Application Ref:	3/2021/0280	 Ribble Valley Borough Council www.ribblevalley.gov.uk	
Date Inspected:	13/5/2021		
Officer:	AD		
DELEGATED ITEM FILE REPORT:		Decision	Refusal

Development Description:	Proposed conversion of barn to two dwellings and conversion of agricultural buildings to provide home office space and garages.
Site Address/Location:	Newhurst Farm Anna Lane Bolton By Bowland BB7 4NZ

PROJECT	Newhurst		
CLIENT	Holt		
TITLE	Plans - Sheet 2 of 2 PLANNING 2nd / Roof		
DRAWING NO'	SCALE	STATUS	REVISION
ID-GA-02	Various	P

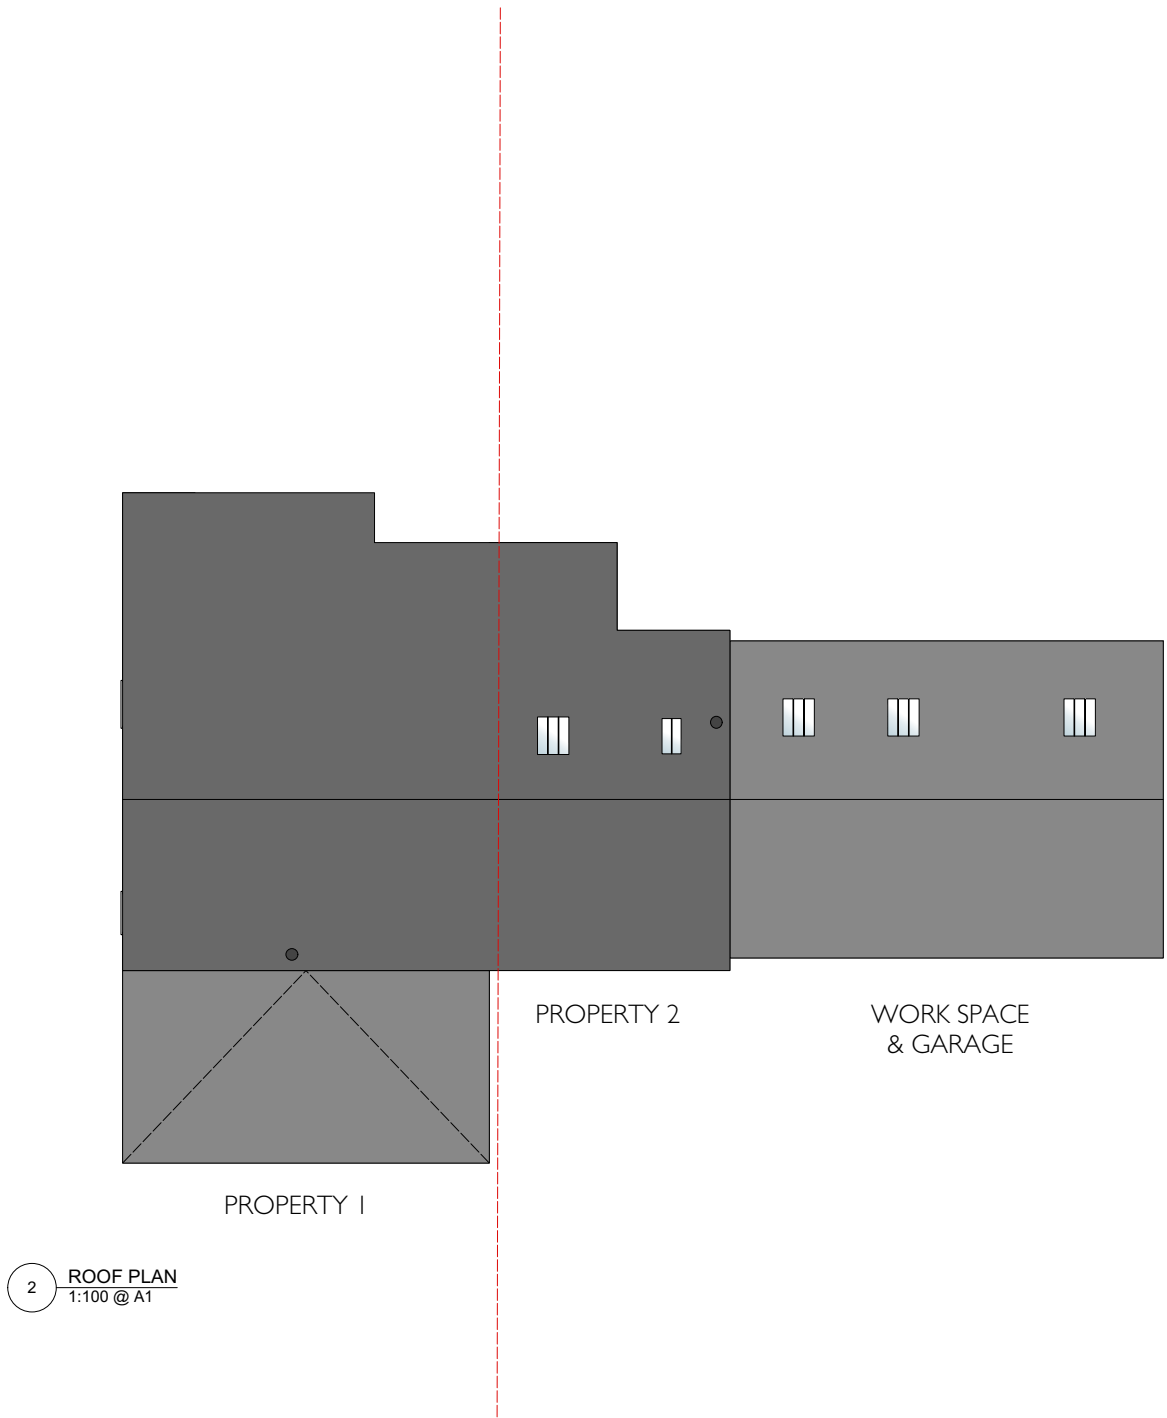
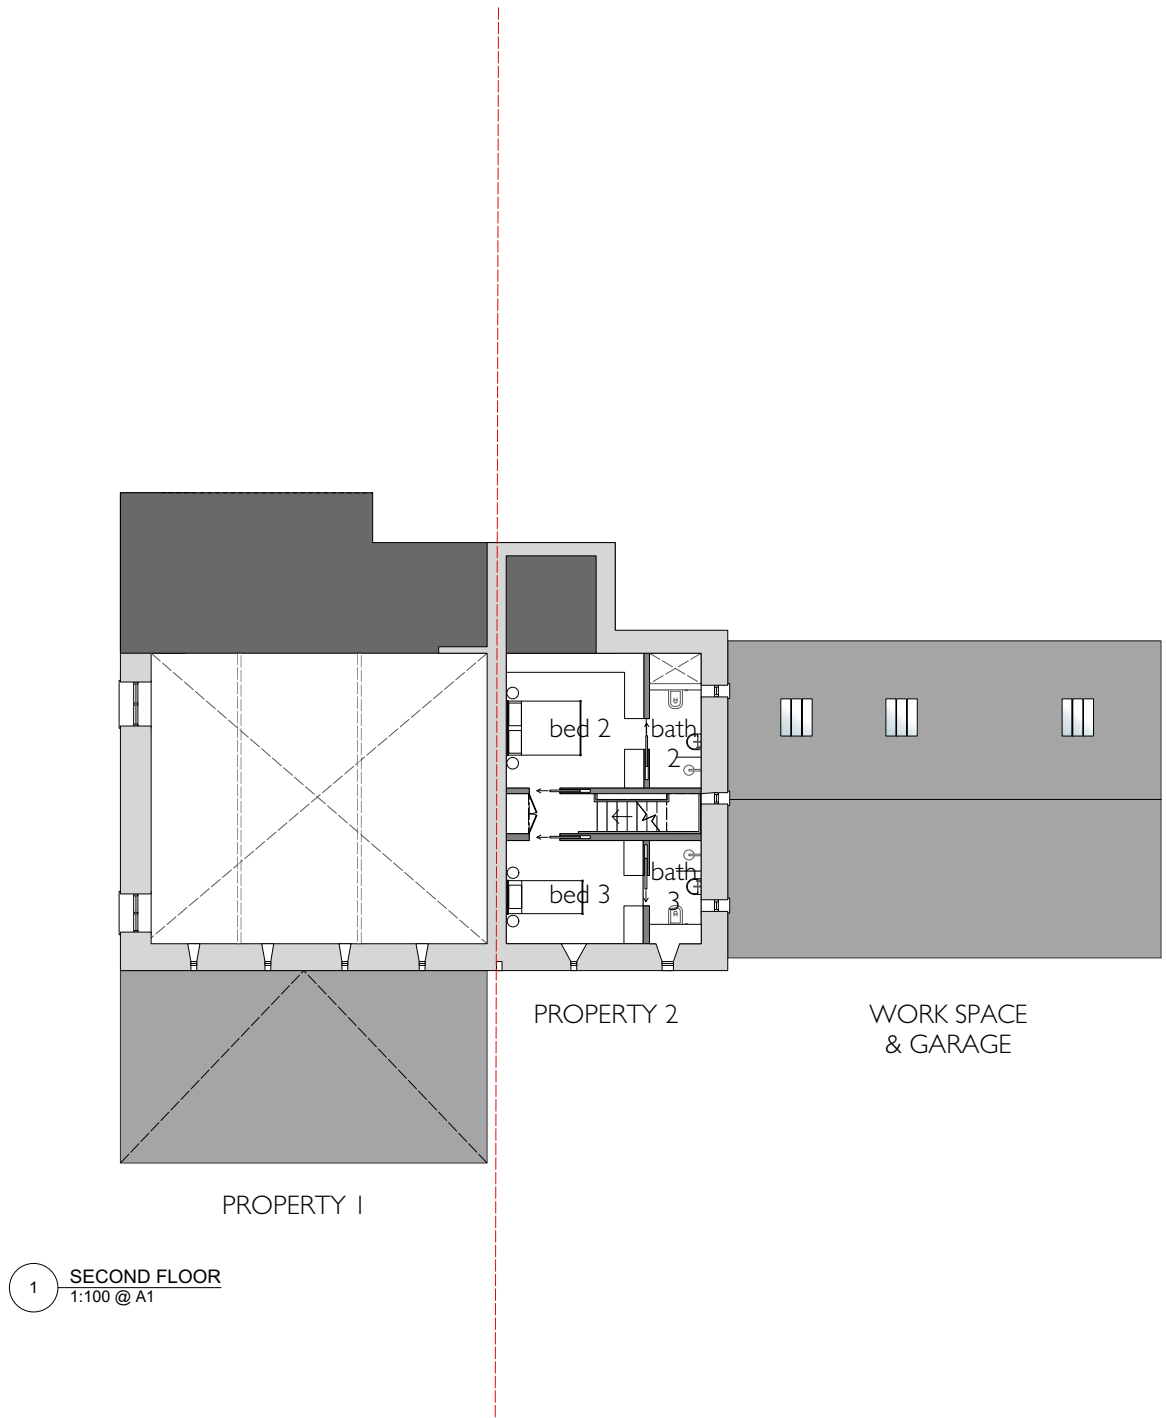
“Significant aspects of the interior would be retained where possible” (Heritage Statement). However, the plans identify *“Existing timber trusses to property No 2 to be removed and replaced with steel ones to achieve head-height for second floor”* (*“The roof structure appears entirely original”* – HS 5.8).

Rooflights are prominent (entrance elevation to the bank barn) and conspicuous in the stone slate roof. Only necessary because of the formation of a new second floor in Property 2.

PROJECT	Newhurst		
CLIENT	Holt		
TITLE	Plans - Sheet 1 of 2 PLANNING Ground / 1st		
DRAWING NO'	SCALE	STATUS	REVISION
ID-GA-01	1:100 @ A1	P

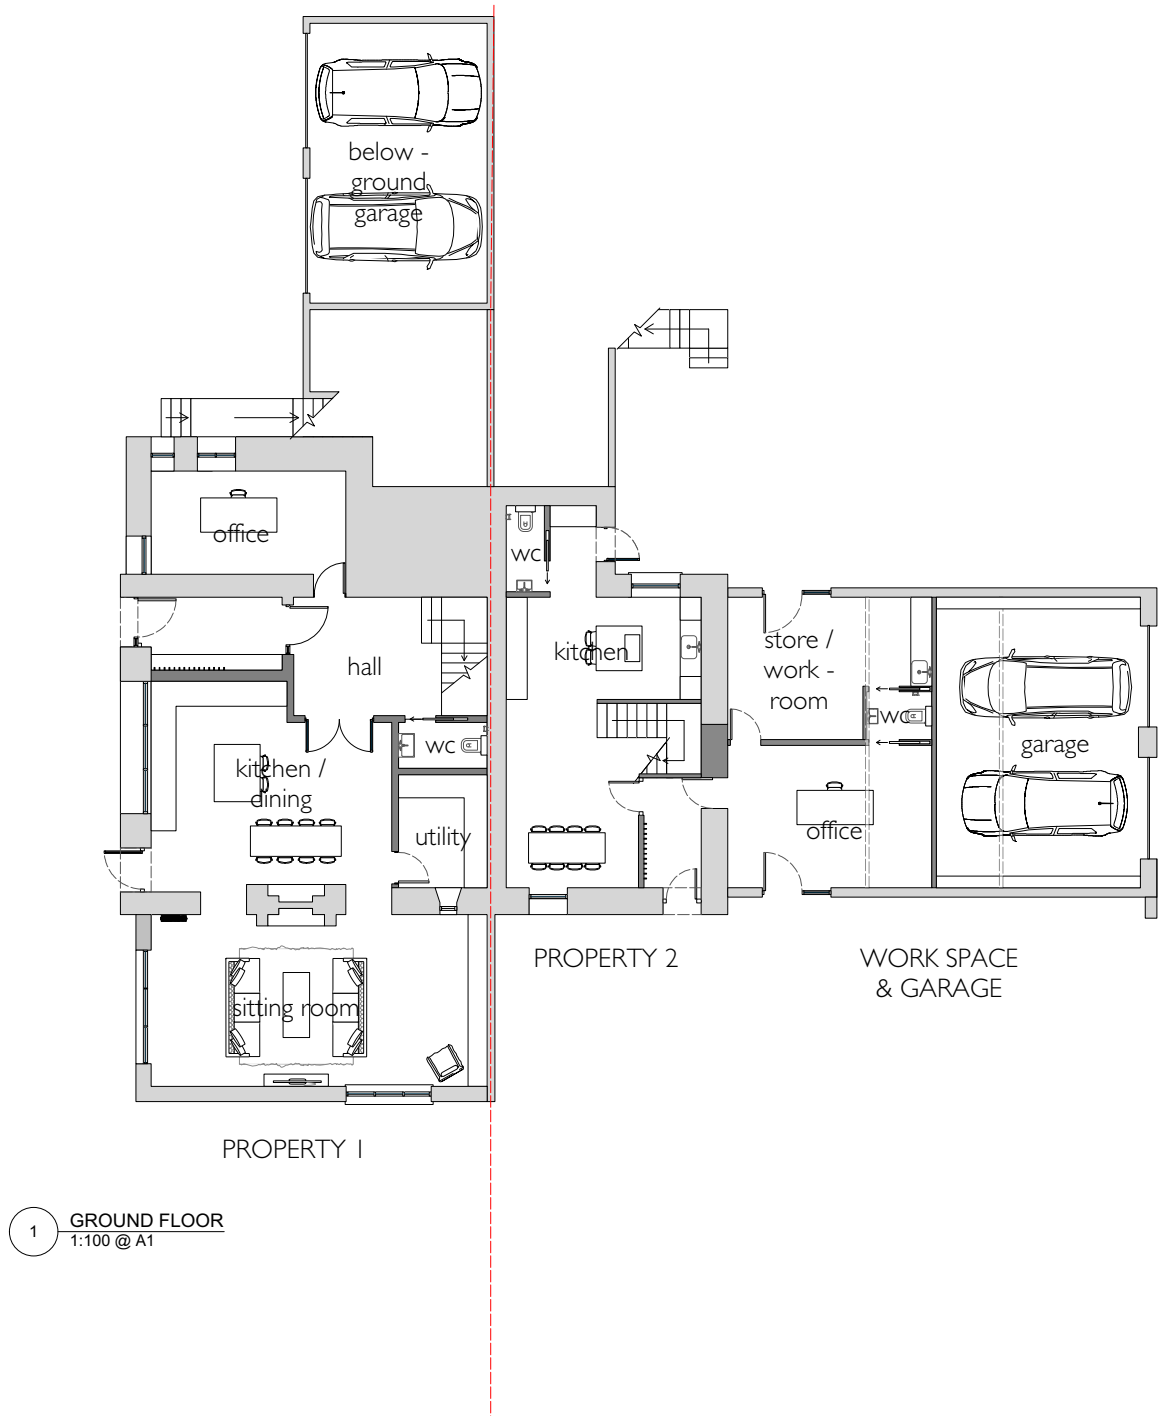
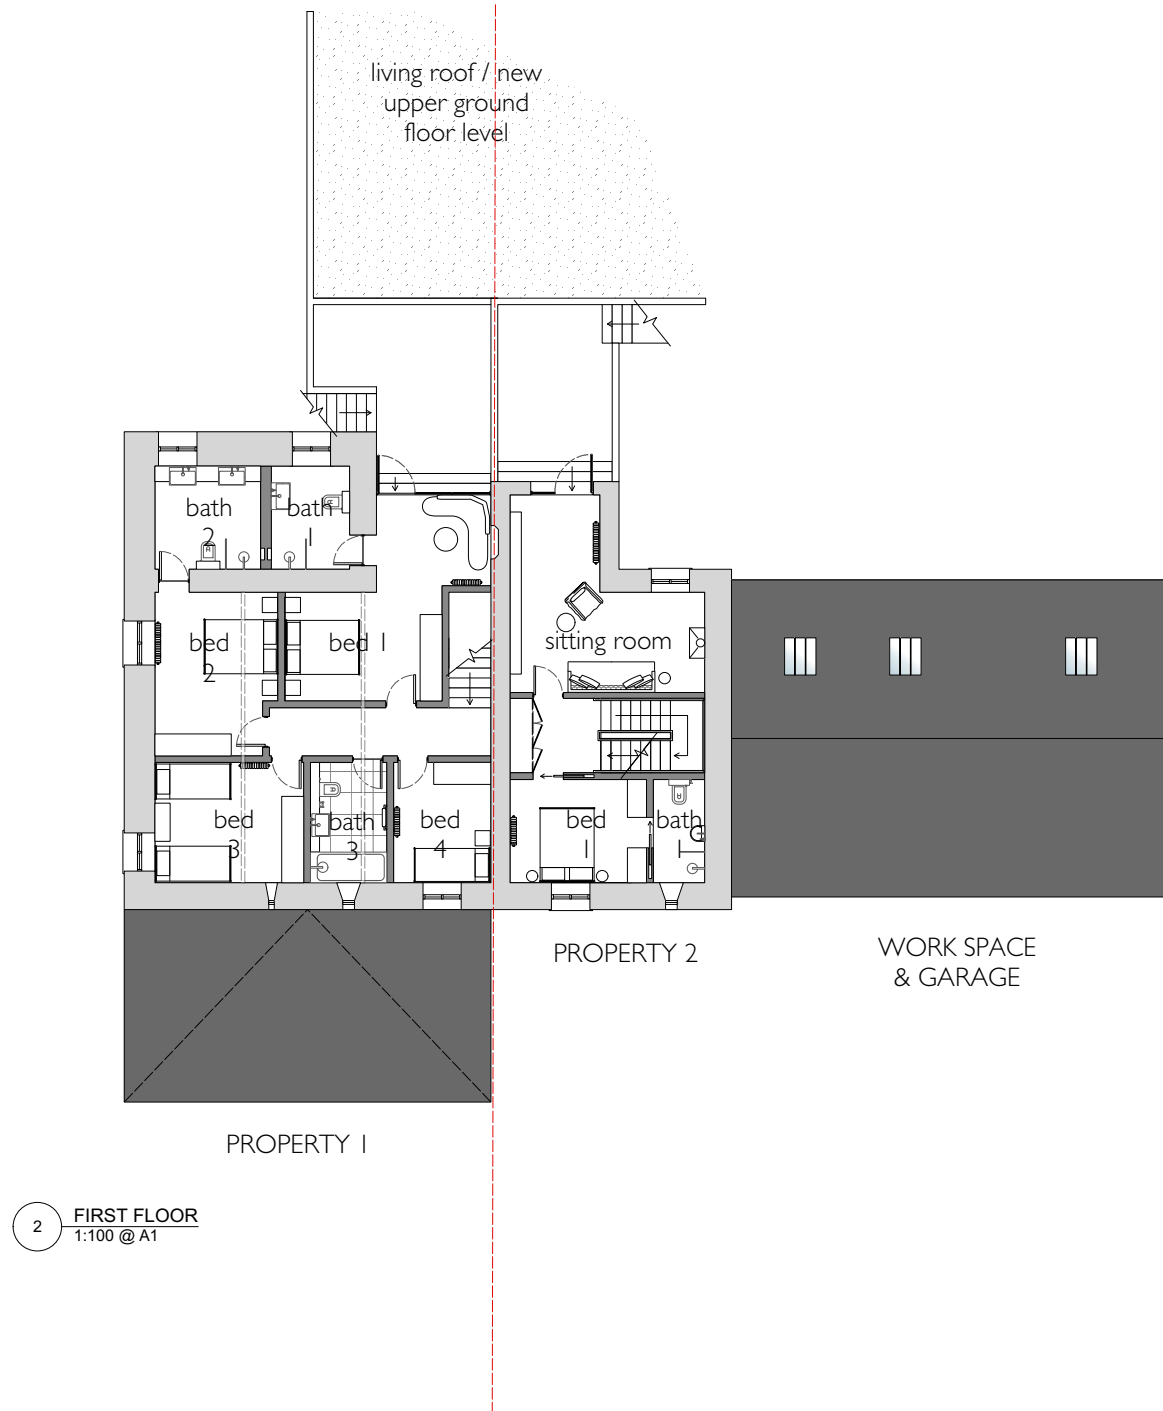
Windows and doors are proposed dark stained timber. Many openings (including incongruous modern openings in size and proportion) are to be reused but proposals also include new openings and rooflights (e.g. in accommodation of a new second floor to Property 2) and the conspicuous partial opening of the top of the winnowing door and enlargement of adjoining breathers (*“regular arrangement of breathers, in two rows”* – HS 5.3).

Loss of the bank to the distinct bank barn including replacement with a terrace and double-garage;

Glazing of incongruous modern openings including 4-light window to the SE elevation.

Enlarged breather openings to prominent NE elevation (disrupting regular pattern of historic breathers).

Partial unblocking and glazing of the winnowing door to the NE elevation (which confuses interpretation of building function).

Retention and modification of incongruous and utilitarian modern agricultural buildings. Including overtly domestic horizontally emphasised triple-light window and glazed triple-door to the prominent NE elevation addition and two sets of double-width doors to the NW elevation addition.

The treatment of two new openings to the SW elevation of Property 2 appears to match the historic domestic windows in the SE elevation – this confuses an understanding of the historical development of the building.
